KITTTITAS COUNTY COMMUNITY DEVELOPMENT SERVICES

January 22, 2016

RE: Nicholson Setback Variance Application (VA-15-00004 Nicholson)

**SITE PLAN
SCALE 1" = 10'**

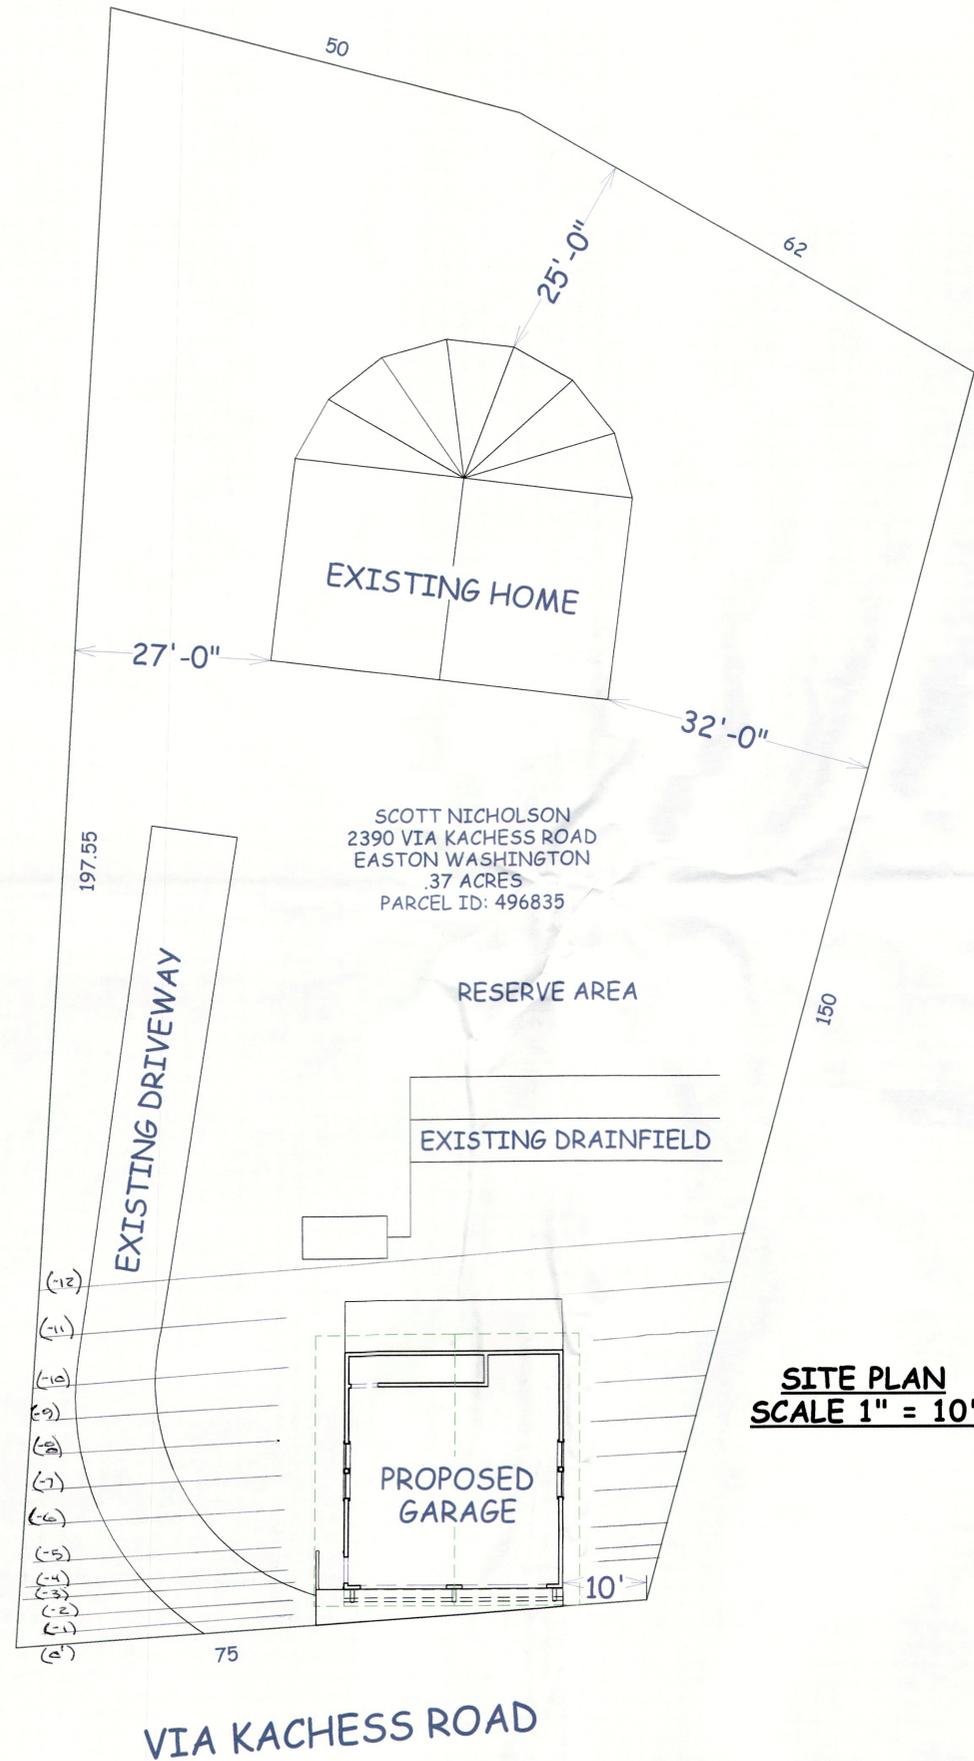
Community Development Services will require a revised site plan indicating the distance from the proposed garage to the ordinary high water mark of Lake Kachess.
